Longfield Solar Farm

Applicant Responses to ExA Further Written Questions

Document Reference : EN010118/EX/8.15(A)

Deadline 6

**FIGURE NUMBER**

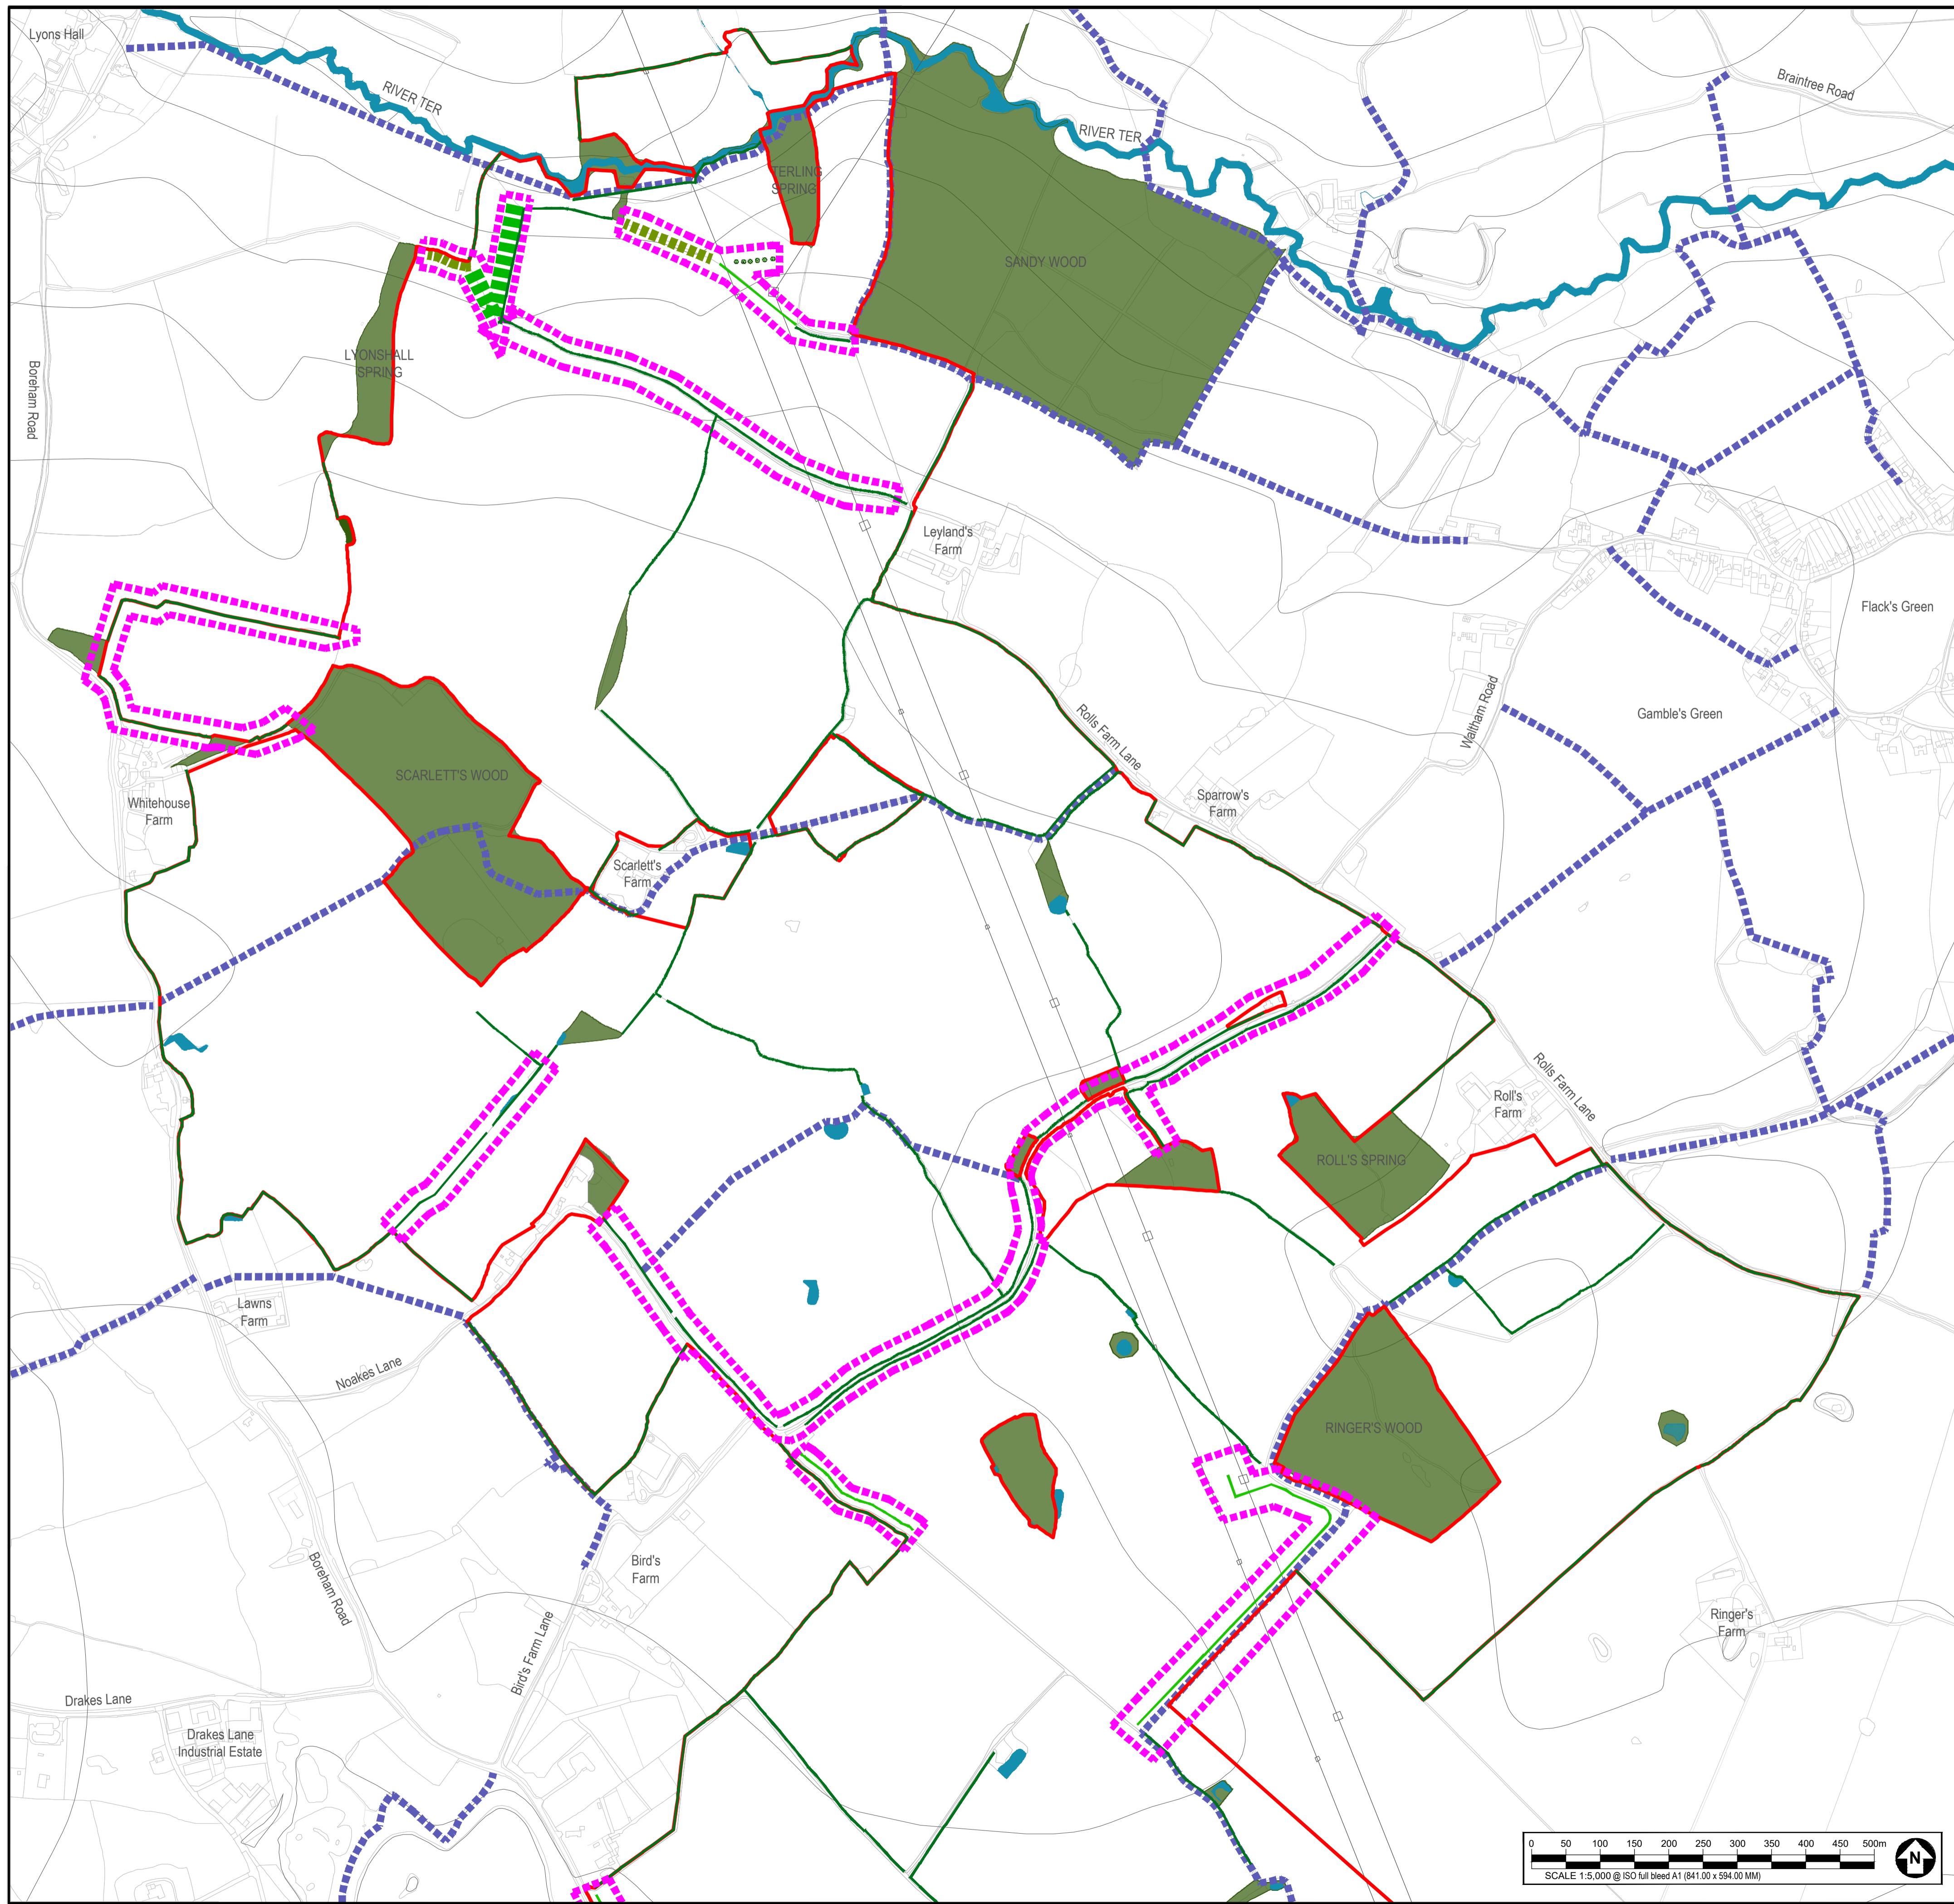
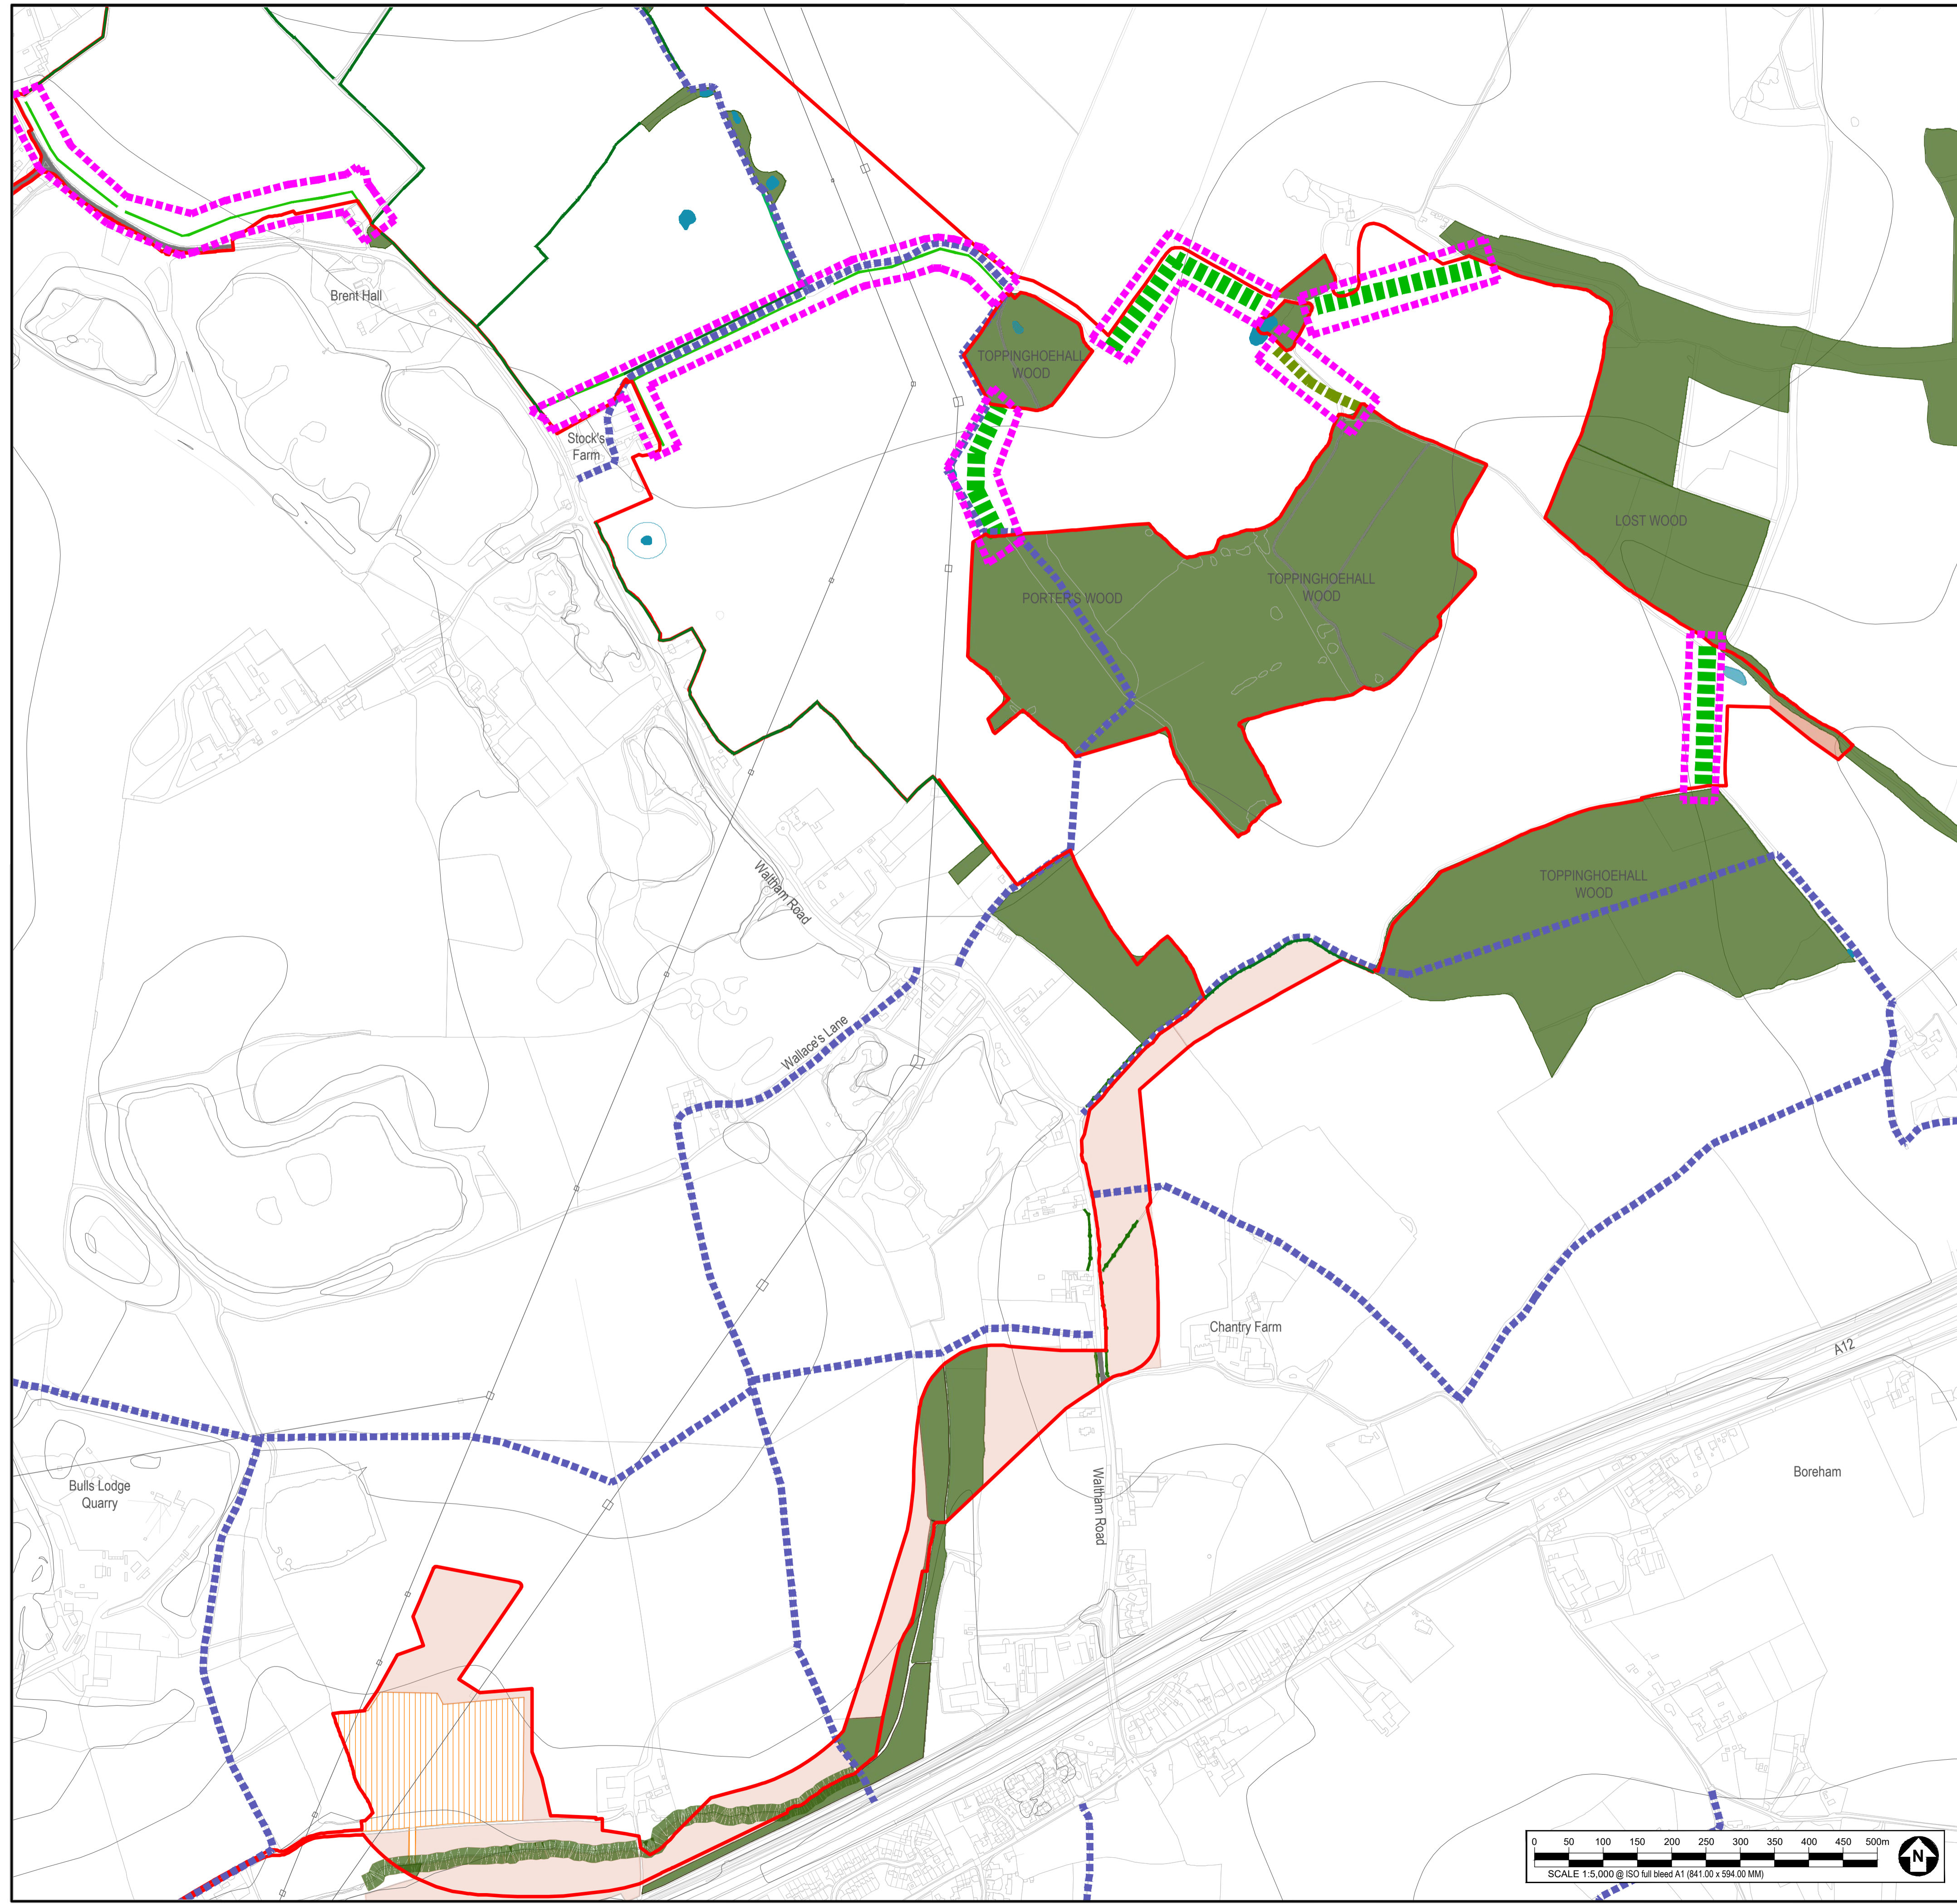
<p>3.2.8</p>	<p>Applicant</p>	<p>The ExA notes that the oLEMP submitted at Deadline 5 [REP5-006] does not include Annex A. Please provide a complete and fully consolidated version of the oLEMP.</p>	<p>This error has been <u>corrected</u> in the document and submitted at Deadline 6.</p>
